Rezoning Transportation Analysis

Petition Number: 2021-089

General Location Identifier: 10503127

Date	Description
08-20-2021	First Review (WB)
10-15-2021	Second Review (AO)
11-22-2021	Third Review (AO)

SHEET NUMBER:  
**RZ1.0**

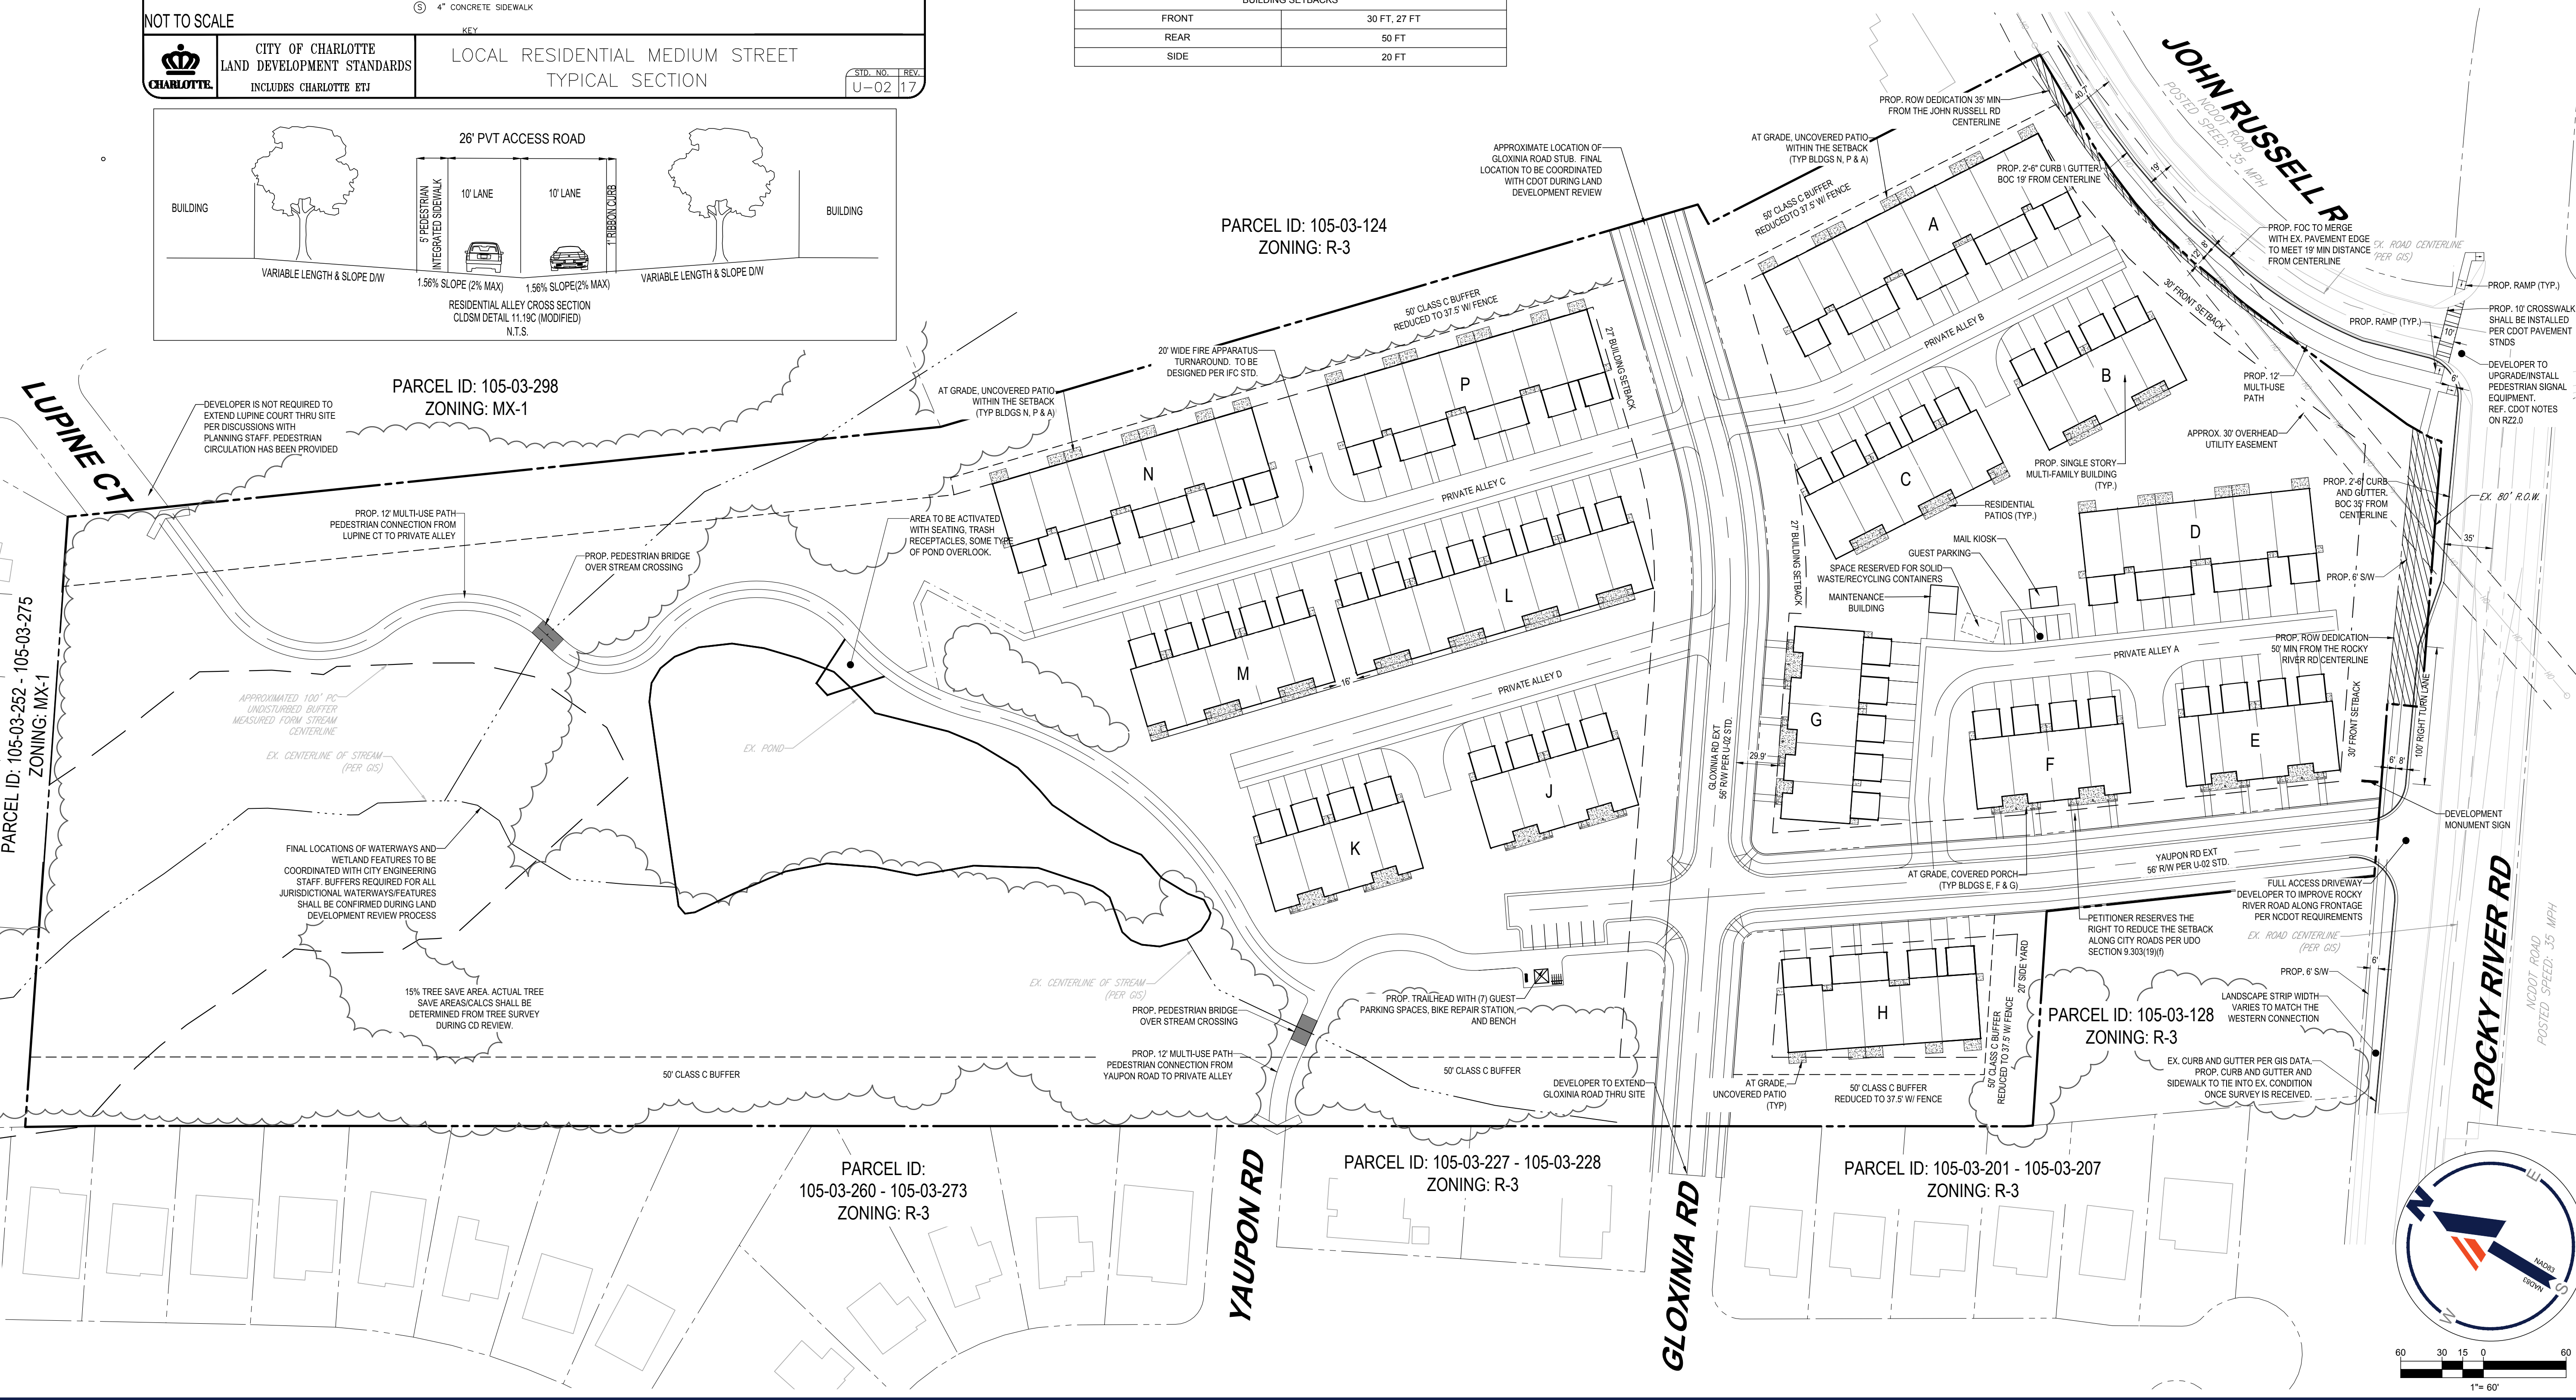
1. ~~Curbline:~~

a. ~~**Rocky River Road:** The future curb and gutter shall be located 35' from centerline to back of curb. This should generally match what has been set up for future widening, west of the project's limits.~~

b. ~~**John Russell Road:** The future curb and gutter shall be located 19' from centerline to back of curb.~~

~~Label and dimension the curb and gutter from the centerline for each road on the site plan.~~

3. ~~Revise site plan and conditional note(s) to commit to dedicate 50' (minimum) right of way from the Rocky River Road centerline. The site plan shall label and dimension the right of way from the road centerline.~~

4. ~~Revise site plan and conditional note(s) to commit to dedicate 35' (minimum) right of way from the John Russel Road centerline. The site plan shall label and dimension the right of way from the road centerline.~~

5. ~~Site plan and conditional note(s) revisions are needed to commit to providing a 100' right turn lane at the site's access on Rocky River Road per the NCDOT's standards. The proposed right turn lane should be dimensioned.~~

6. ~~Site plan and conditional note(s) revisions are needed to commit to construct bicycle facilities by installing the curb and gutter 35' from the Rocky River Road centerline per the Charlotte's BIKE Policy. The proposed curblines should match what has been set up west of the project.~~

7. ~~Revise site plan and conditional note(s) to commit to construct an 8-foot planting strip, and 6-foot sidewalk on Rocky River Road per Chapter 20. Tie into the existing sidewalk west of the site to provide pedestrian connectivity and accessibility in accordance with PROWAG and the Charlotte Walks plan. The site plan shall label and dimension both items from the back of curb and gutter.~~

8. ~~Revise site plan and conditional note(s) to commit to construct accessible ramps and a crosswalk at the John Russel Road Intersection to provide accessibility in accordance with PROWAG and ADA. The site plan shall label and dimension all items.~~

Technical Clarification (10-18-21): The crosswalk width to be 10' wide unless otherwise specified.

9. ~~Site plan and conditional note(s) revisions are needed to commit to construct pedestrian and bicycle facilities by installing a 12' multi-use path along the John Russel Road Frontage in accordance with the Charlotte BIKES Policy.~~

10. ~~Site plan and conditional note(s) revisions are needed to commit to upgrade the pedestrian signal equipment at the John Russel Road and Rocky River Road intersection to meet PROWAG and ADA standards. The pedestrian signal upgrade will include APS installation and the relocation of pedestrian signals off existing wood pole~~
